**RE:** UNM Starbucks and Freddie's  
Grading and Drainage Plan  
Engineer's Stamp Date 2-22-2017 (File: K16D075)

## DRAINAGE AND TRANSPORTATION INFORMATION SHEET (REV 11/2016)

**STARBUCKS/FREDDIES**  
**2550 CENTRAL SE**  
**Albuquerque, New Mexico**

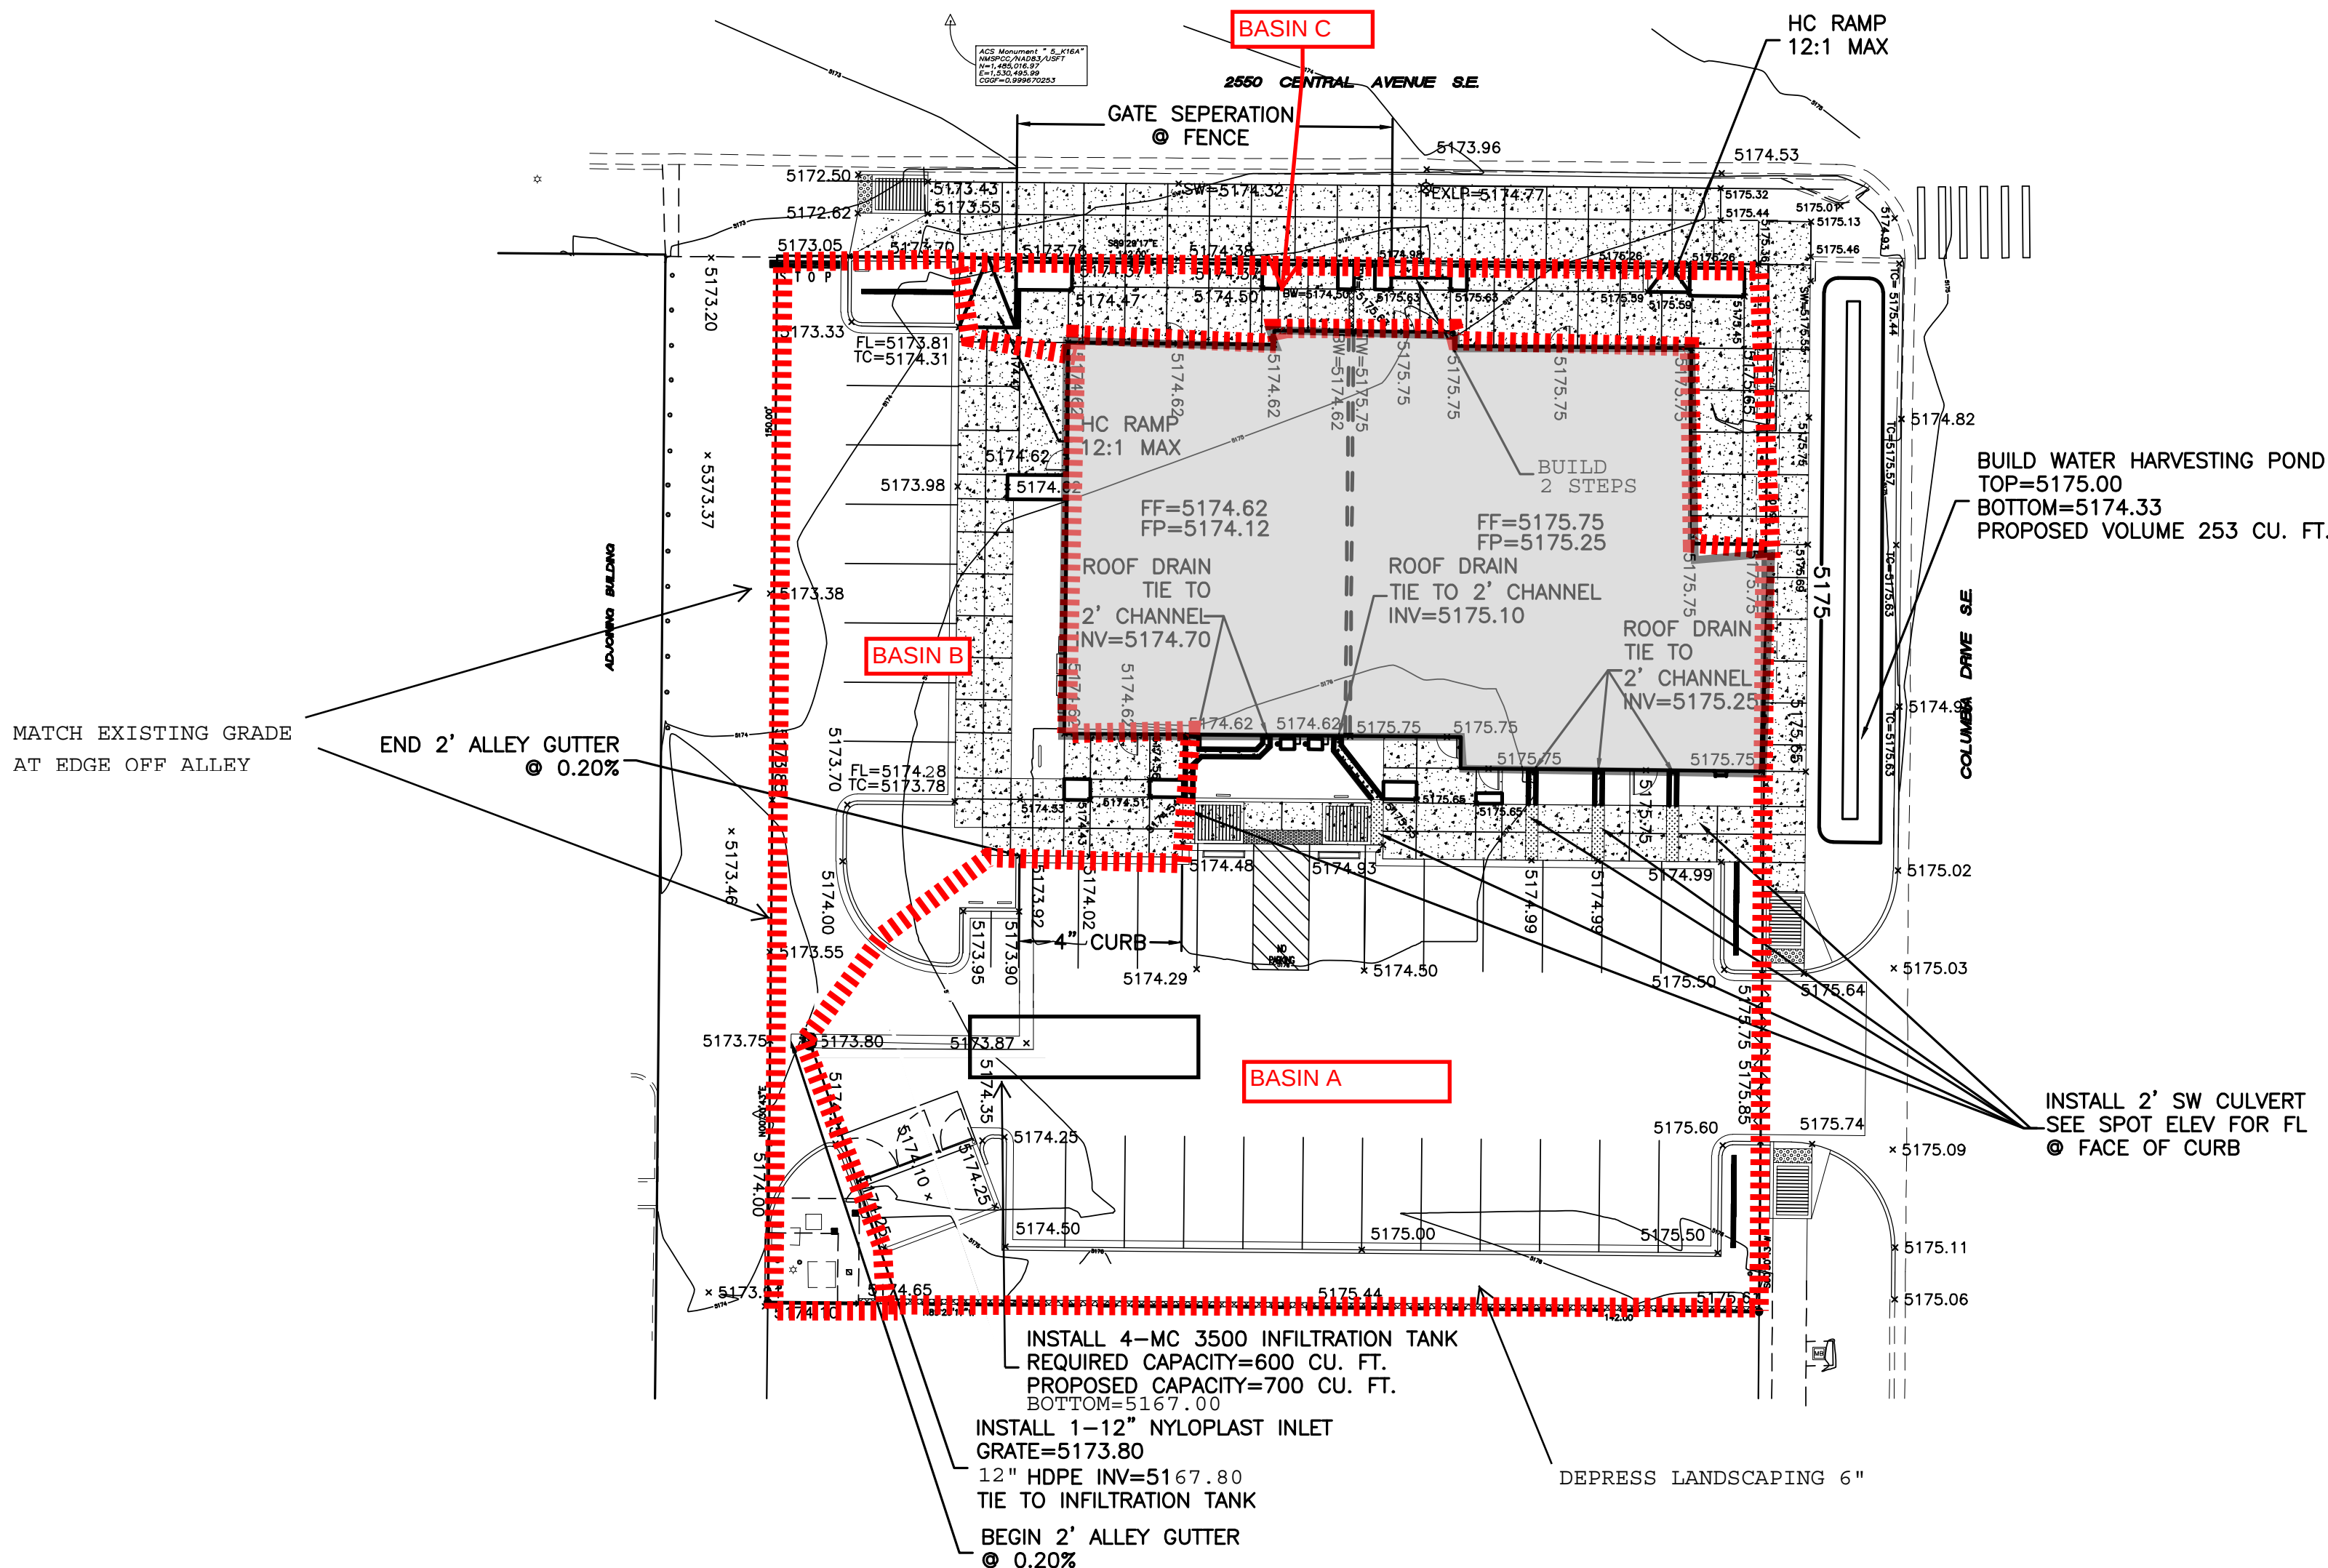
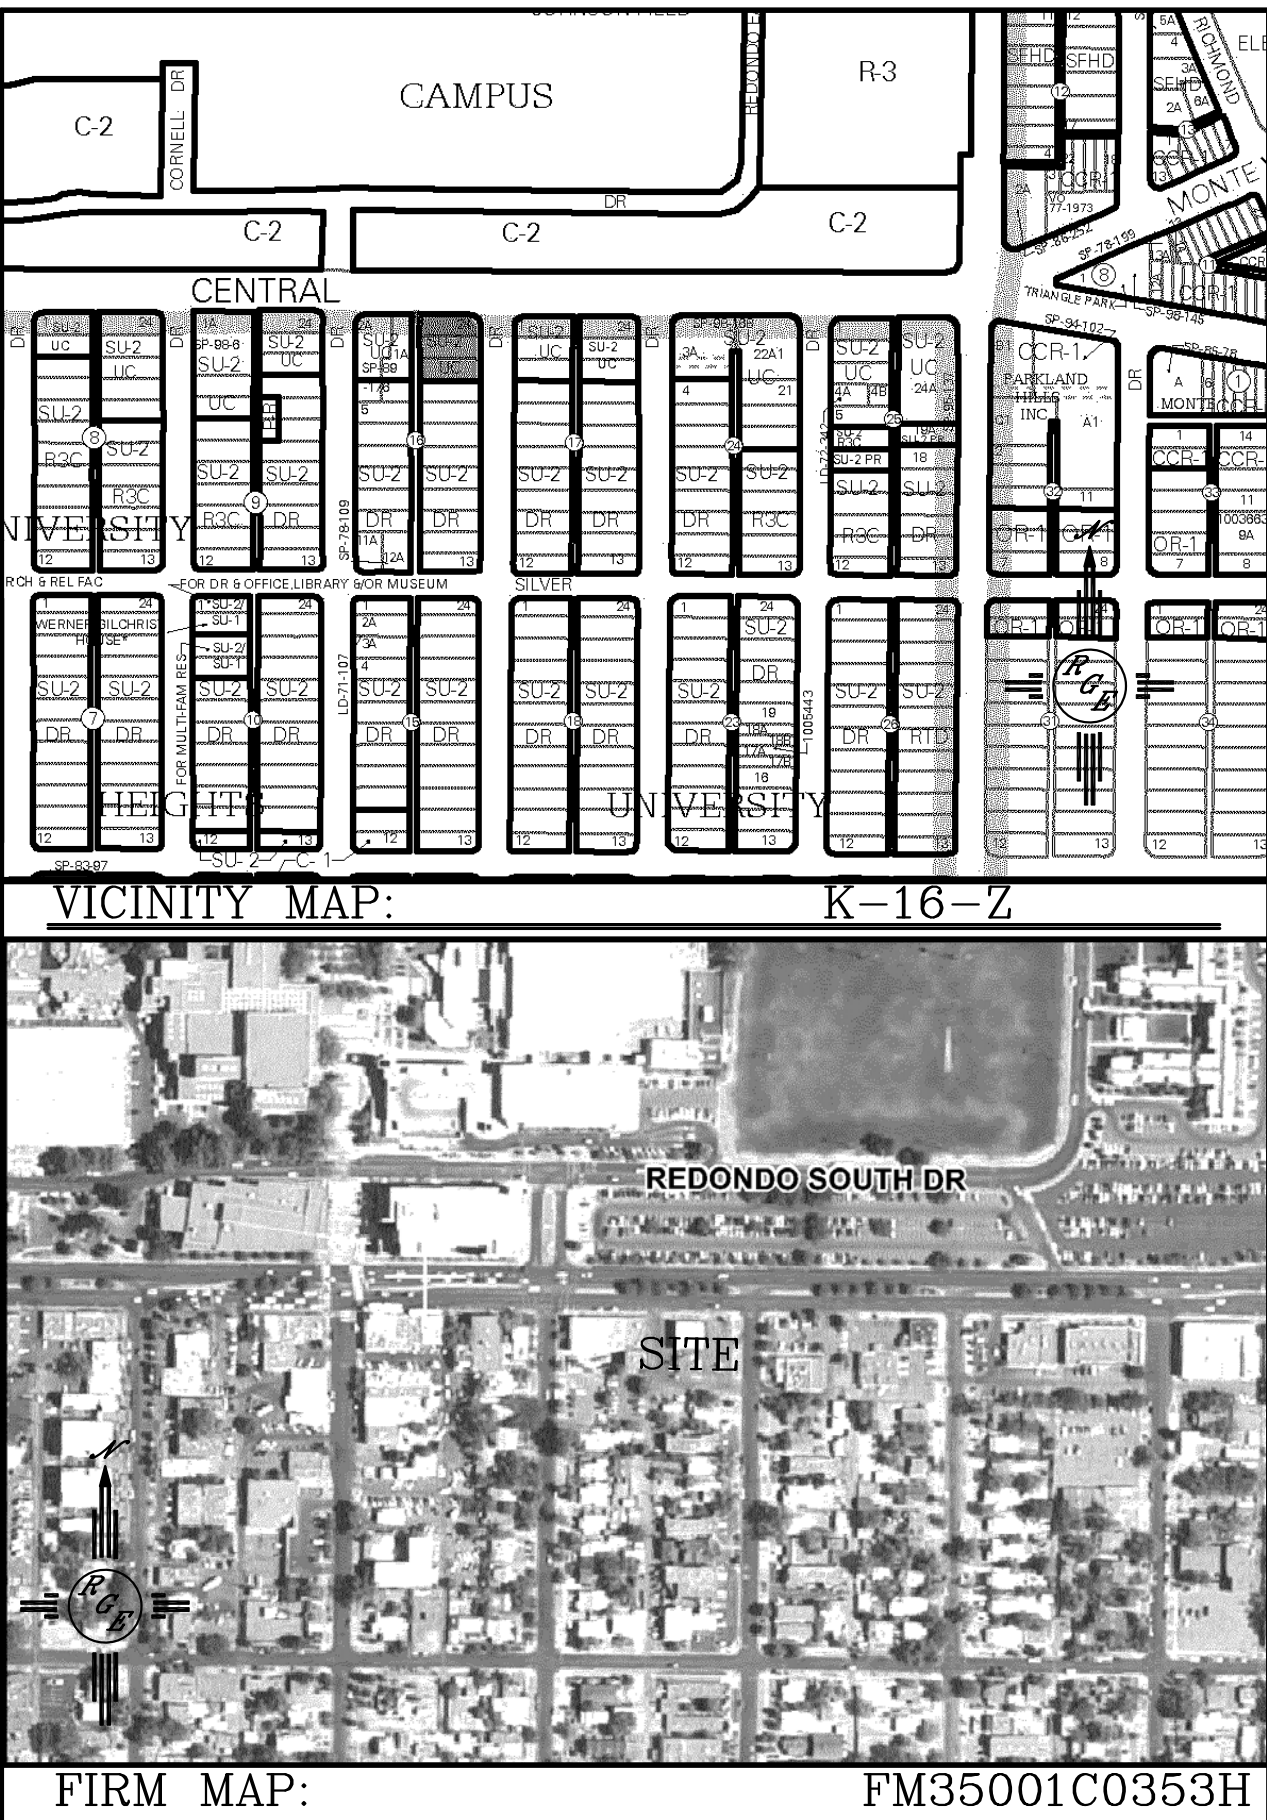
1. Provide build note and grade elevation for the dumpster.
2. Provide narrative for offsite flow.

THIS SITE IS A REDEVELOPMENT OF AN EXISTING SITE . THE EXISTING SITE DISCAHRGES 2.22 CFS TO A PUBLIC ALLEY. THE PROPOSED DEVELOPMENT GENERATES LESS THAN EXISTING FLOW RATES. THE FIRST FLUSH VOLUME WILL BE RETAINED BY THE PLACEMENT OF A INFILTRATOR SYSTEM AT THE OUTFALL FLOW LINE. THE SITE MATCHES THE EXISTI DRAINAGE PATTERNS. AND WILL TIE TO THE EXISTING ALLE NO UPLAND FLOWS IMPACT THE PROPERTY, DUE TO WATER CURB AND GUTTER AND WATER BLOCKS AT DRIVEWAYS
